August 11, 2023

Reference: Engineering Services
6983 US-401
Fuquay-Varina, NC 27526
TE&D Project No.: 2301-020783

As requested, a representative of Tyndall Engineering & Design, PA (TE&D) was on-site to observe the following items per the home inspection report:

FIRST FLOOR PLAN

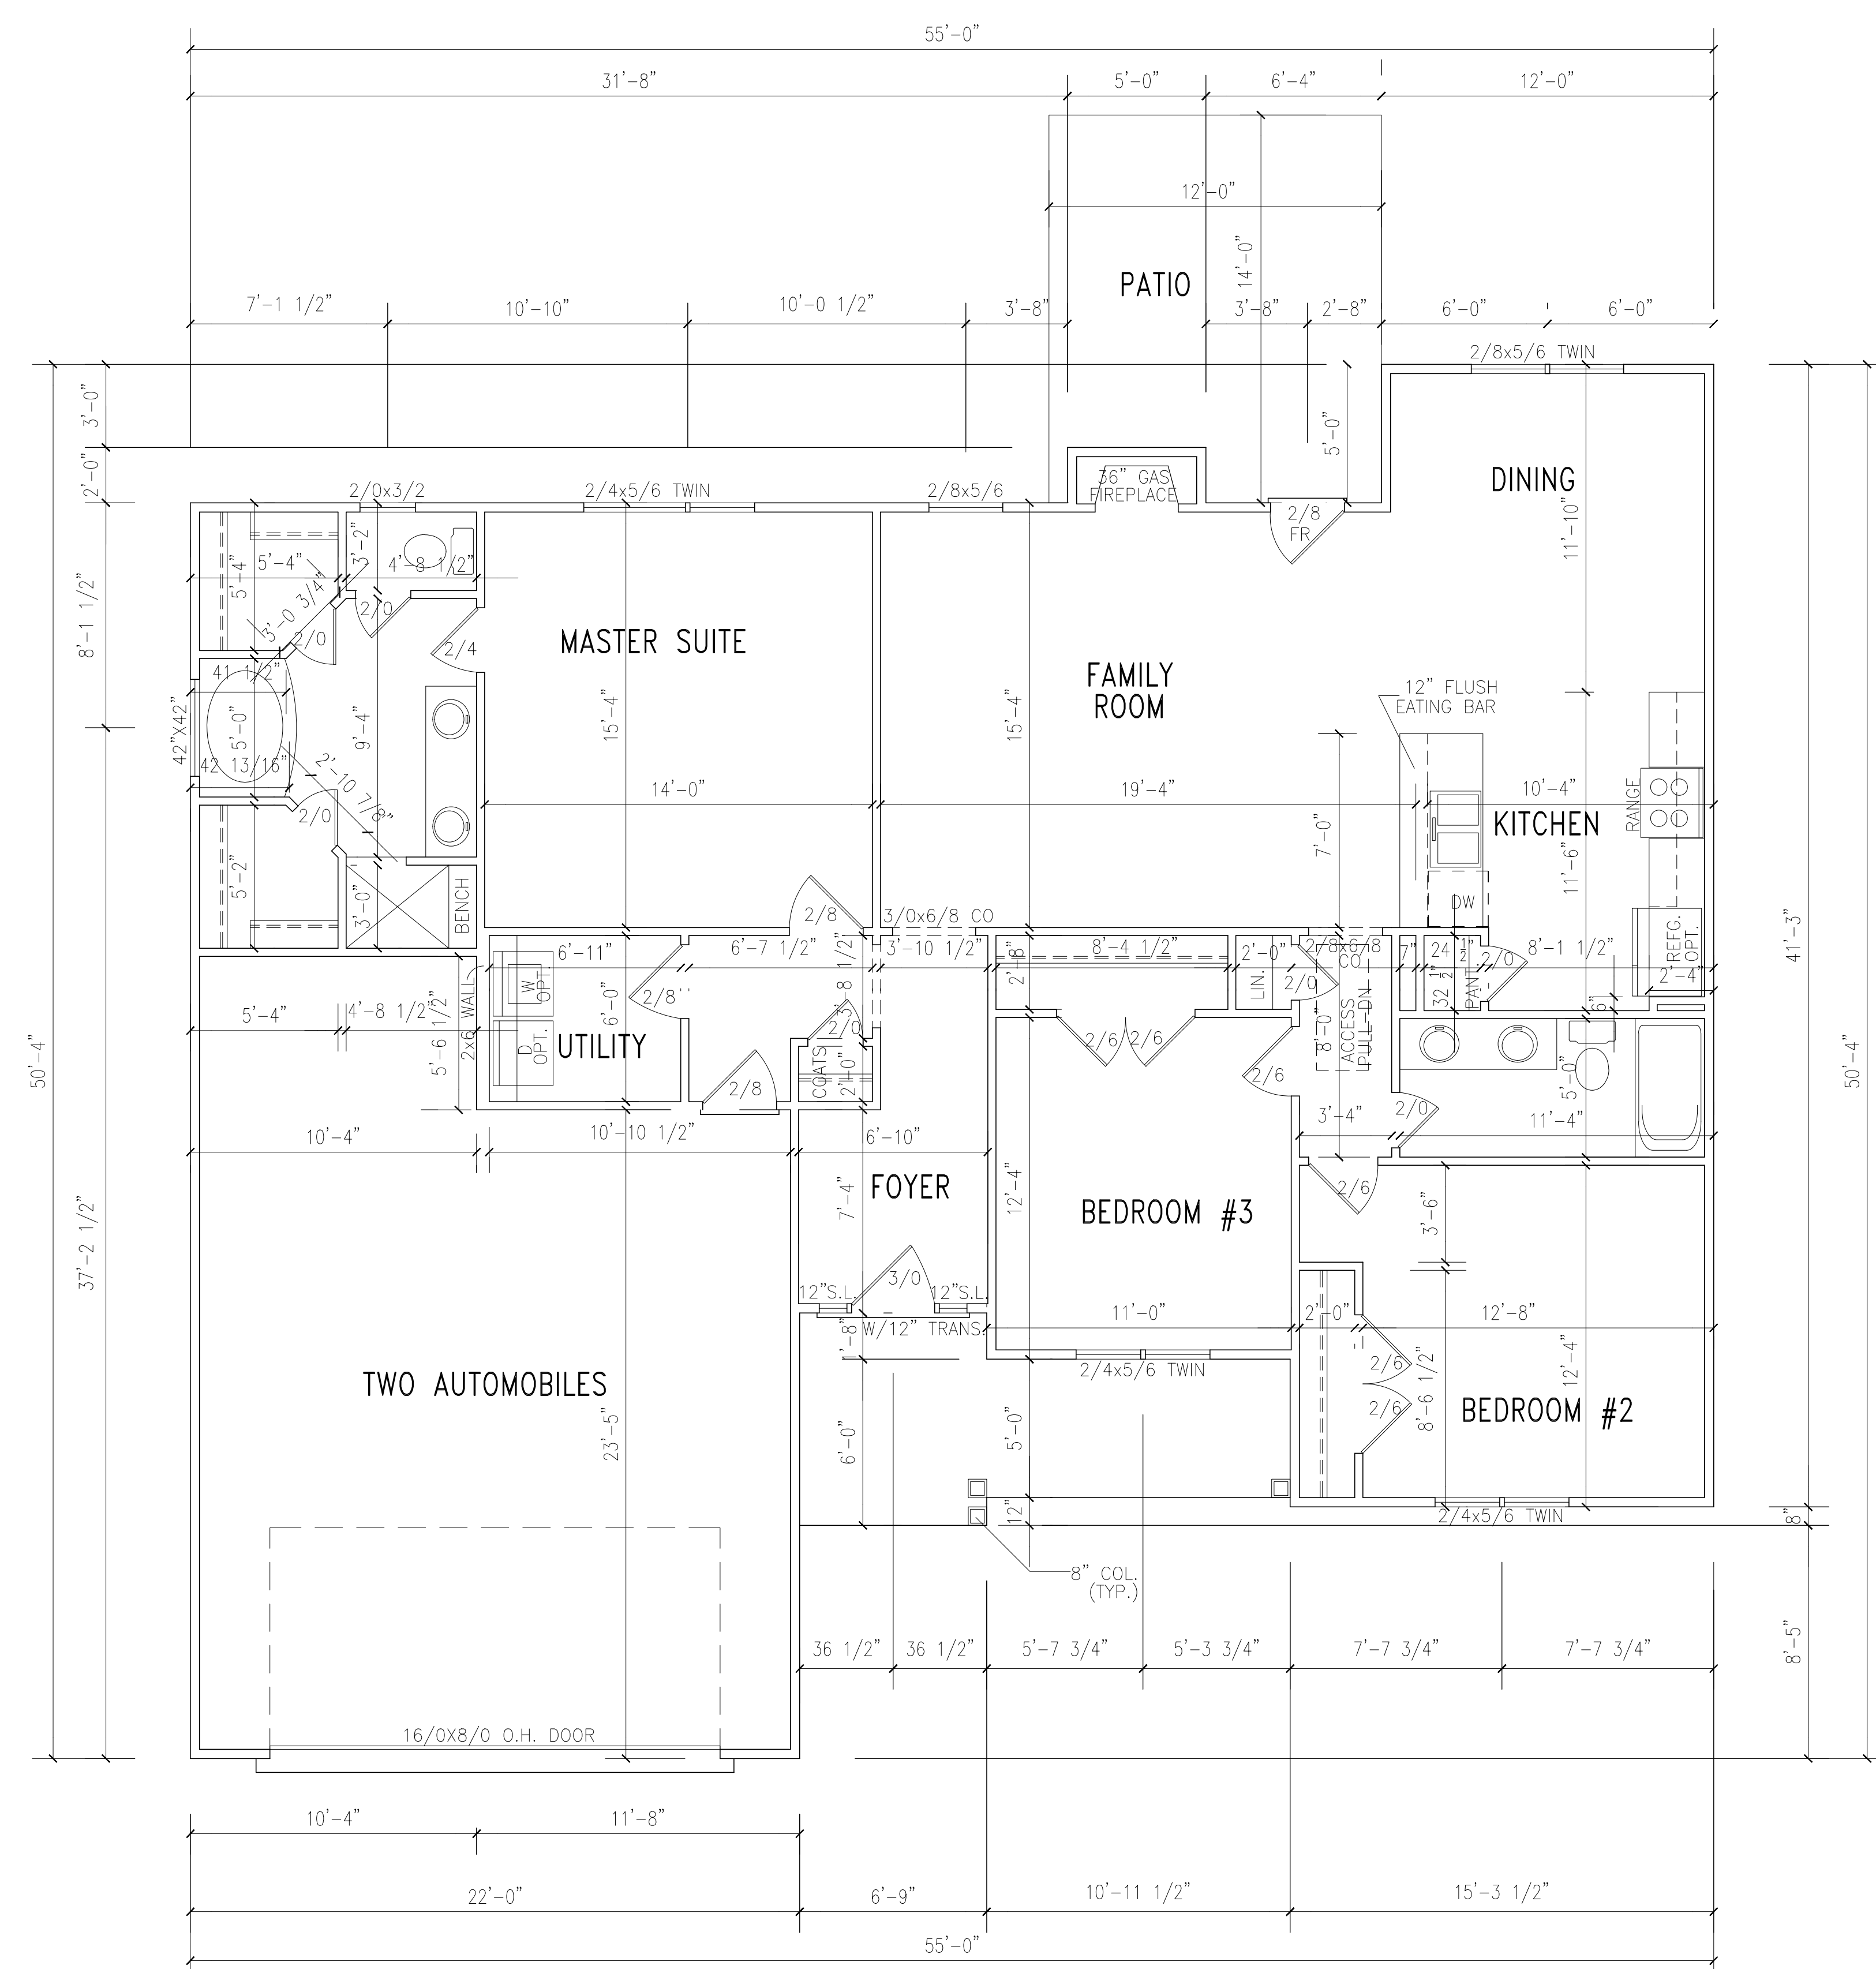
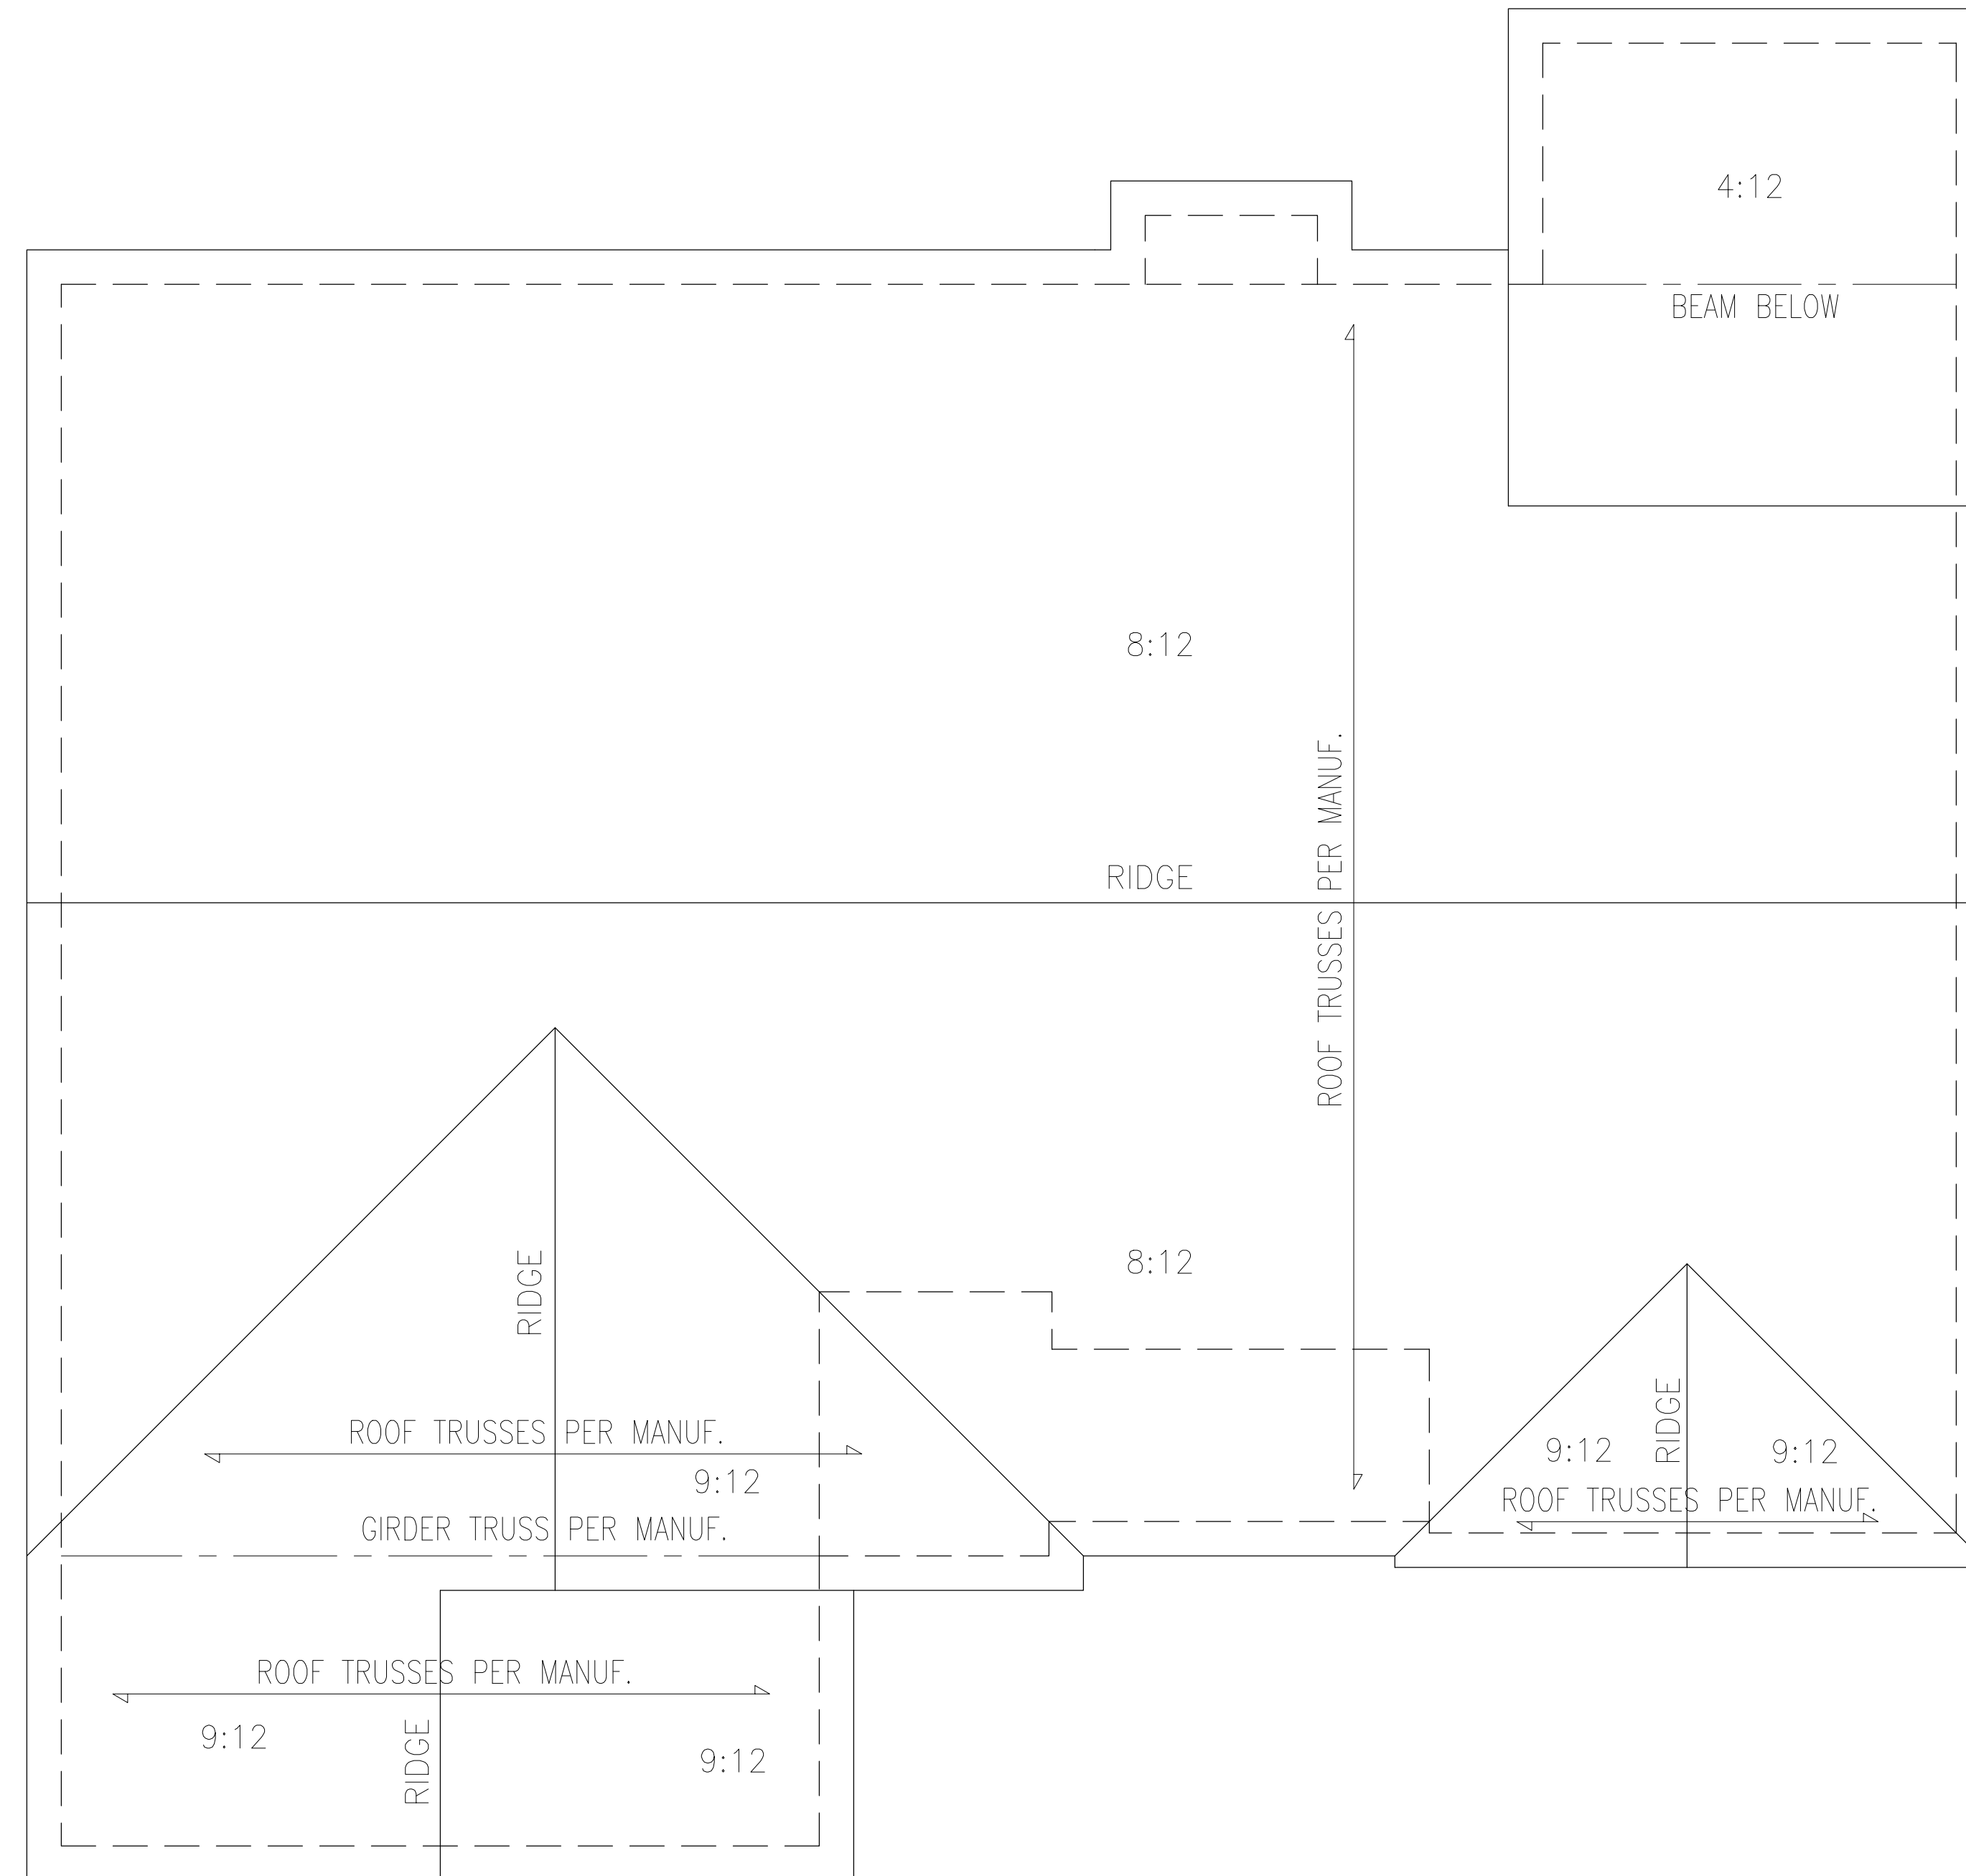
- 2) During our inspection, there were no structural drawings in regards to the first-floor wall/ceiling framing on-site; however, we observed LVLs were used at the following locations:

- a. A (2) 1-3/4" x 9-1/4" LVL header at the middle-front bedroom supported by (2) 2 x 4 jacks and (2) 2 x 4 king studs at each end. Based on our observations and analysis, the current header is adequate to support the anticipated loading conditions.

- b. A (2) 1-3/4" x 11-7/8" LVL header at the garage door supported by (3) 2 x 4 jacks at each end. Based on our observations and analysis, the current header is adequate to support the anticipated loading conditions.
